# Rezoning Transportation Analysis

Petition Number: 2022-115

## Revision Log:

Date	Description
12-28-22	First Review (TM)
4-20-23	Second Review (TM)
6-21-23	Third Review (DR)

RZ-1

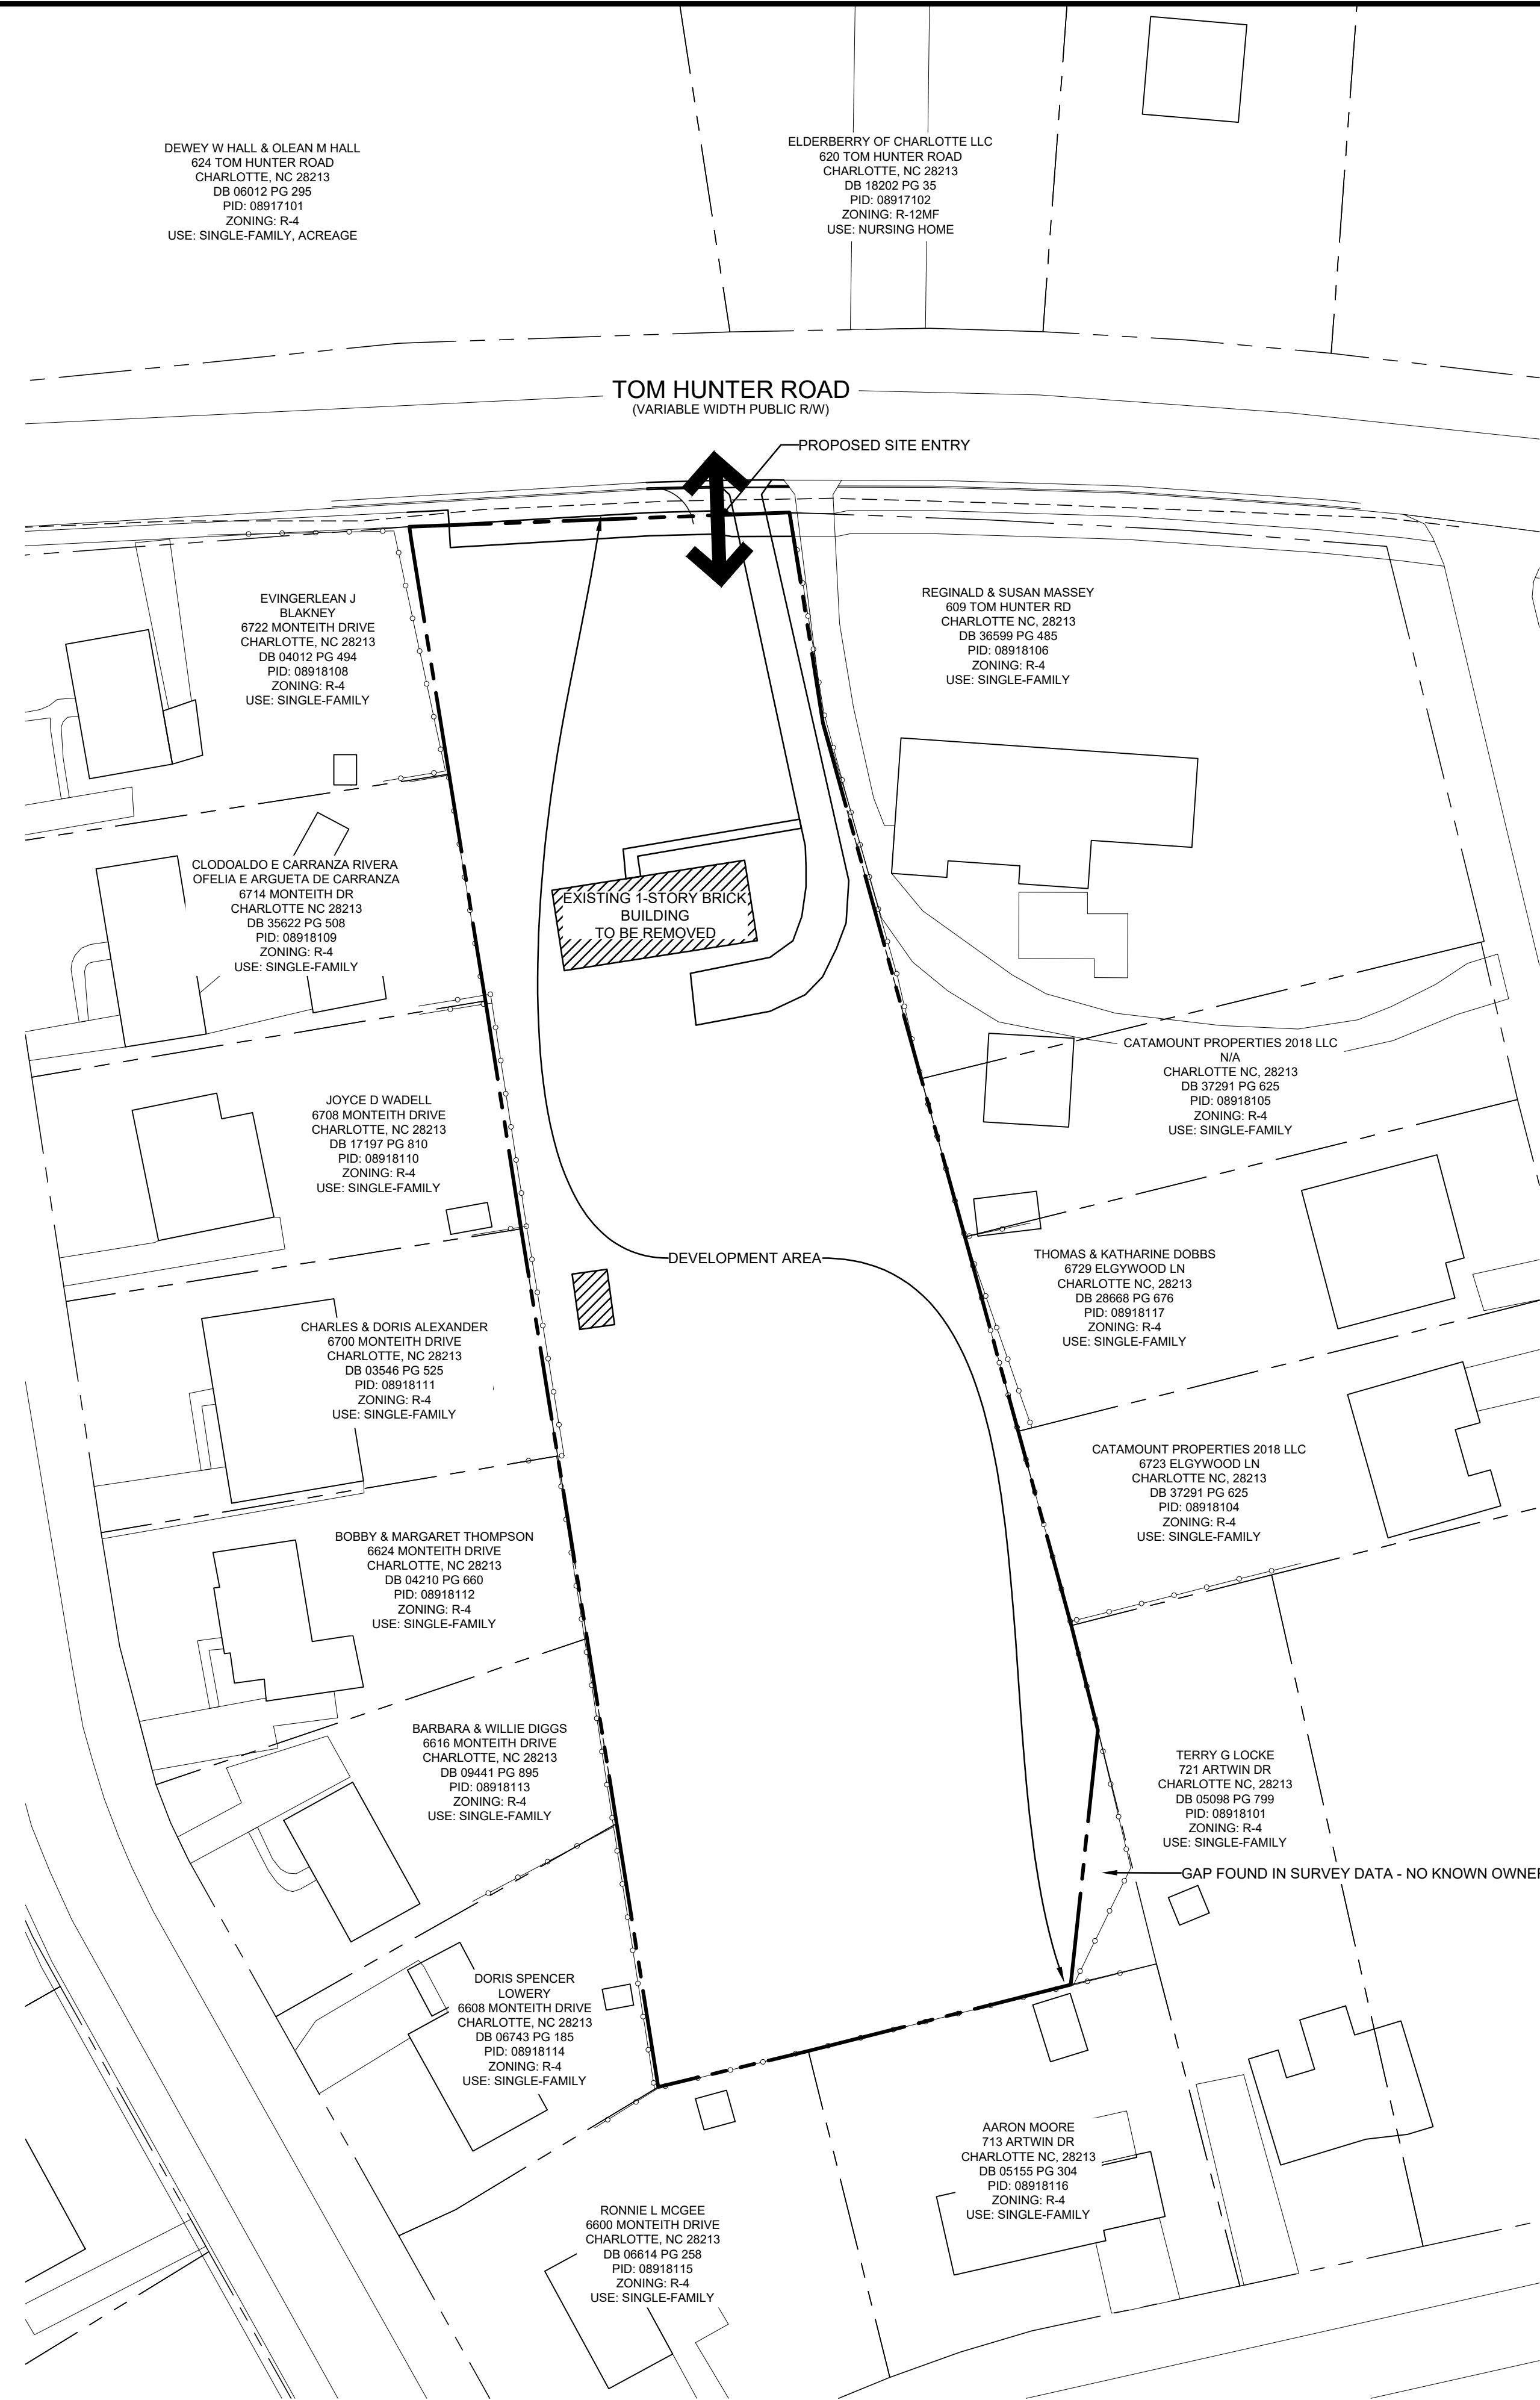
a. ~~**Outstanding Comment From 12-28-22: Tom Hunter Road:** Location of back of curb and gutter to be moved to 24 feet from roadway centerline to accommodate the Charlotte Streets Map with a roadway typical section of CLDSM 11.09 Minor Thoroughfare.~~

~~**Comment Rescinded Clarifying Comment 04-20-23:** Show dimension of 24 feet from roadway centerline to back of curb and gutter in accommodation with Charlotte Streets Map and roadway typical section of CLDSM 11.09 Minor Thoroughfare.~~

~~Label and dimension the curb and gutter from the centerline for each road on the site plan.~~

~~**3. New Comment from 4-20-23:** Revise site plan to properly show access 10 feet from the property line. Dimension access from the property line to the radius point of the site access per City of Charlotte Driveway Regulations.~~

~~**4. Outstanding Comment From 12-28-22:** Revise site plan and conditional note(s) to commit to construct an 8-foot planting strip, and 8-foot sidewalk on Tom Hunter Road per Chapter 19. The site plan shall label and dimension both items from the back of curb and gutter or edge of pavement.~~

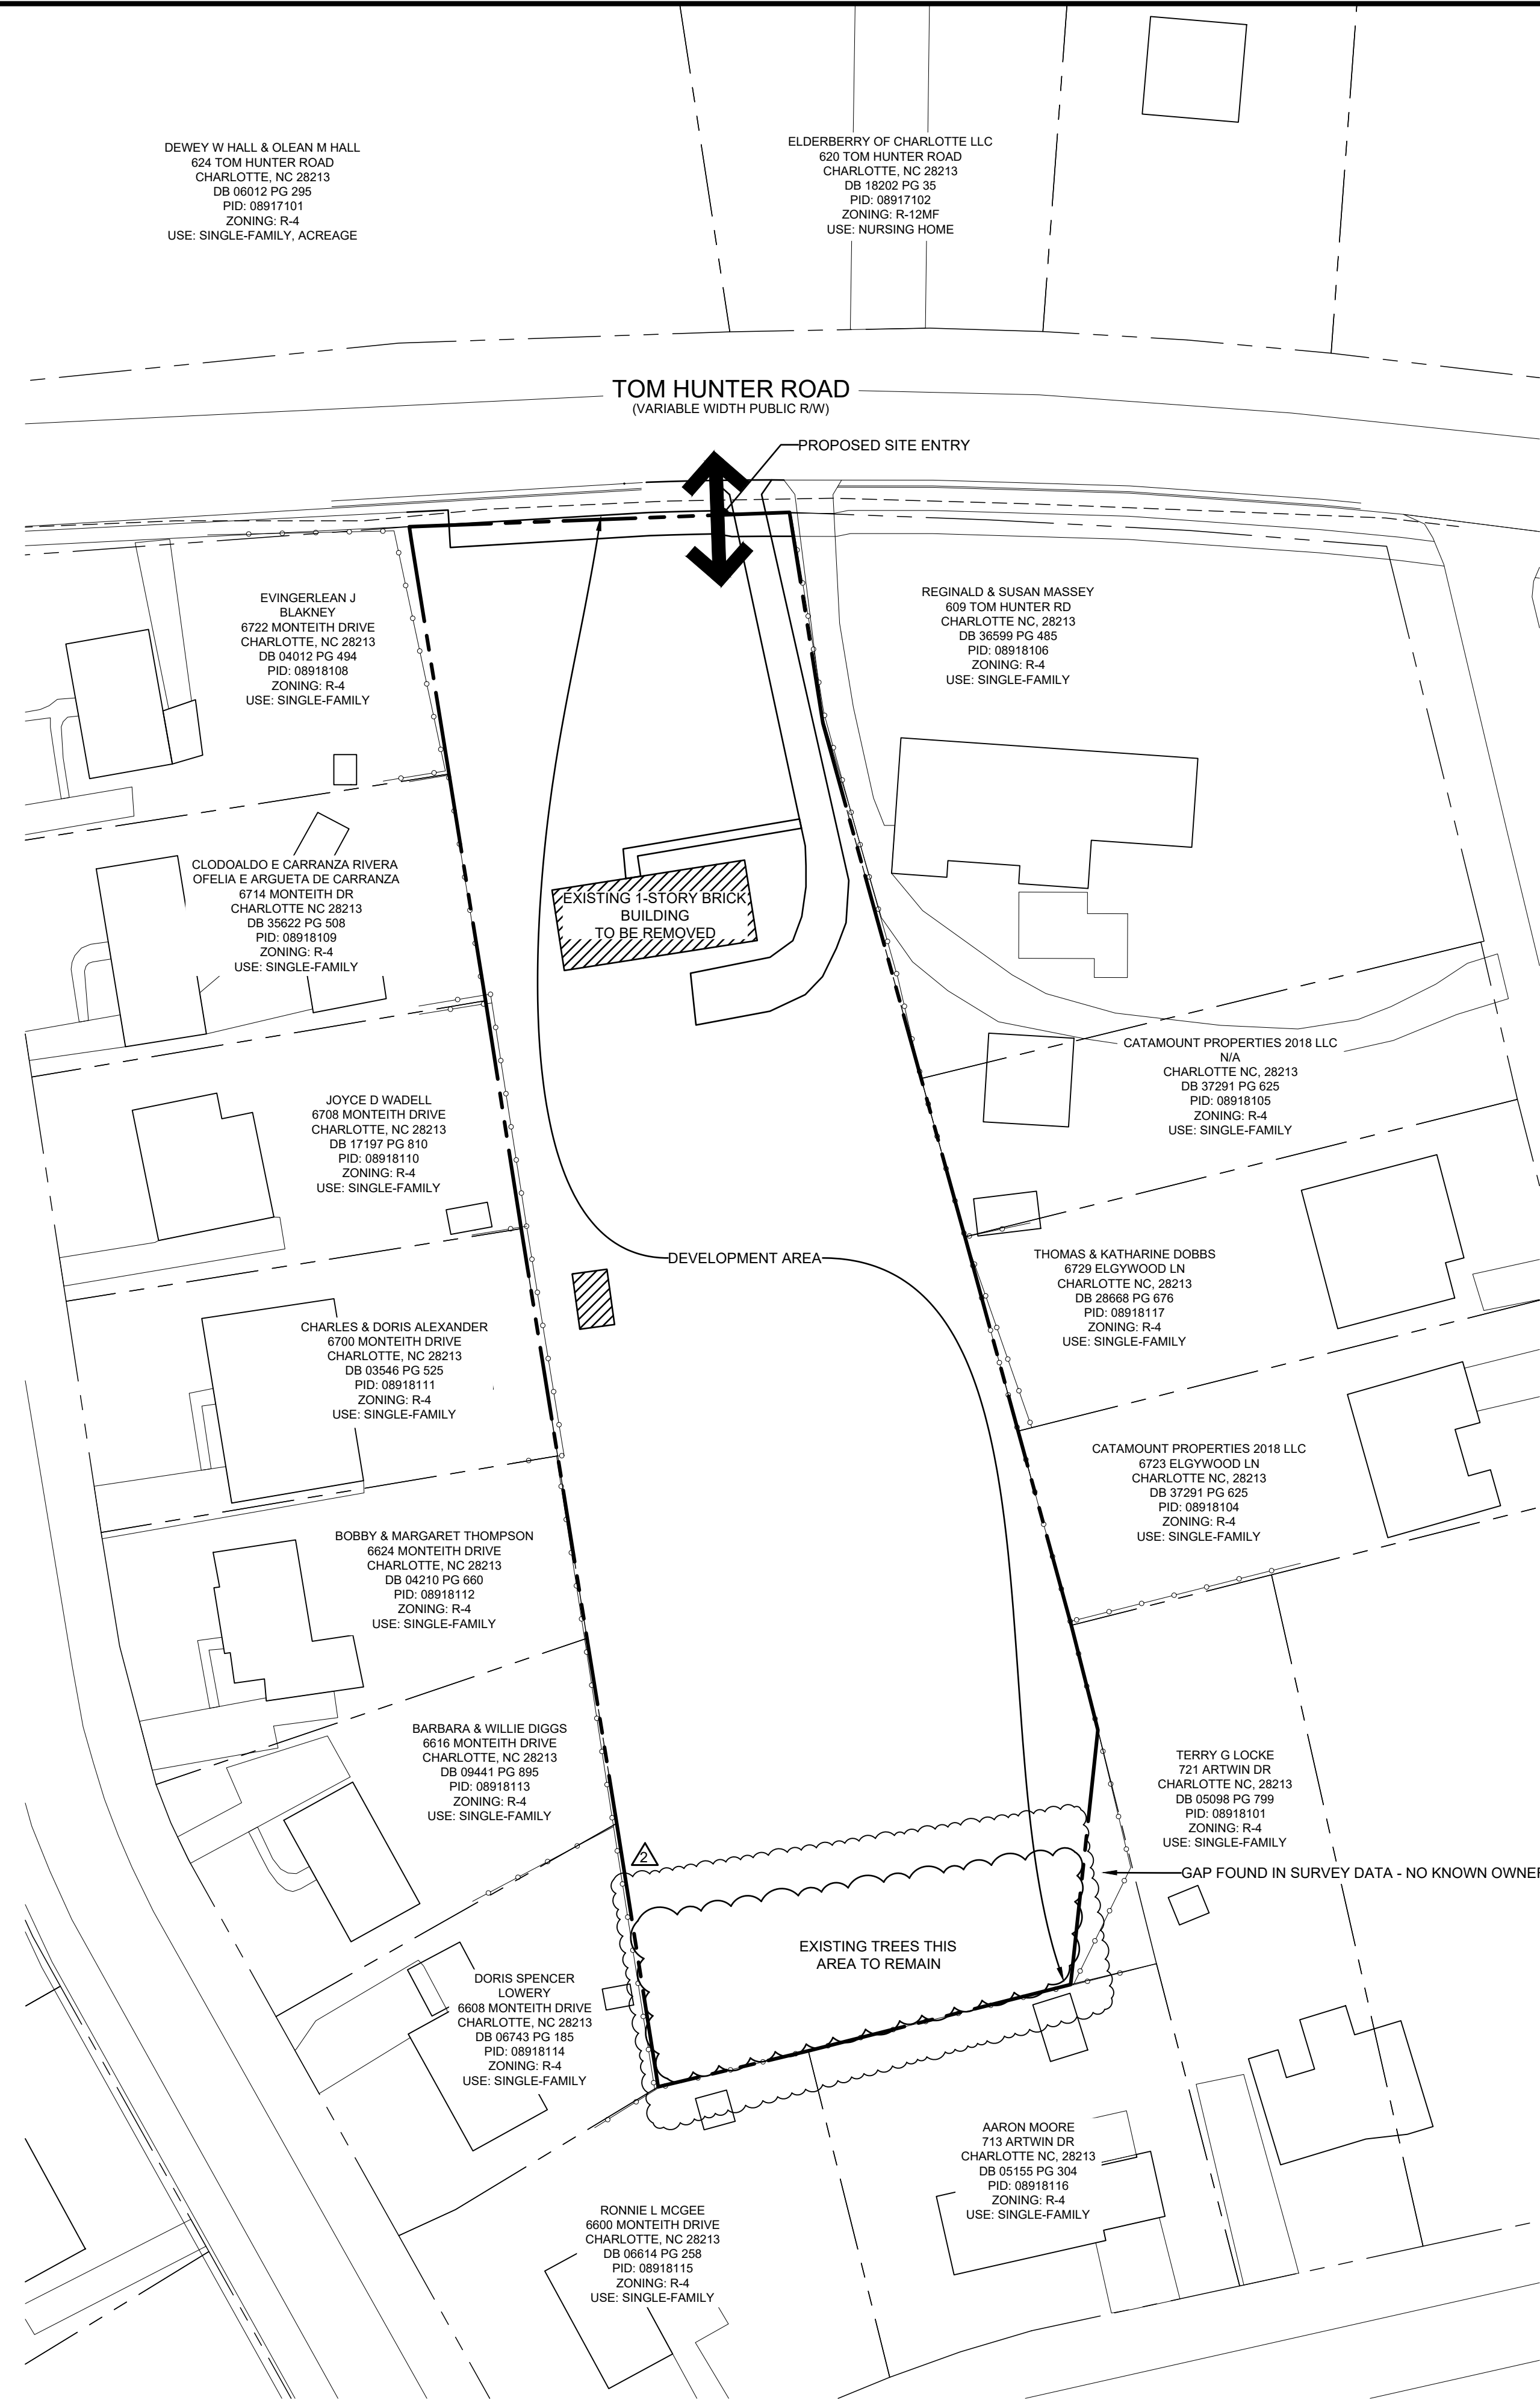
The petition is located on the south side of Tom Hunter Road, a City-maintained minor throughfare east of Monteith Drive, a City-maintained minor collector. A Traffic Impact Study (TIS) is not required for this site due to the site generating less than 2500 daily trips. Petition is providing required streetscape and one access point on Thom Hunter Road. All outstanding CDOT issues have been addressed.
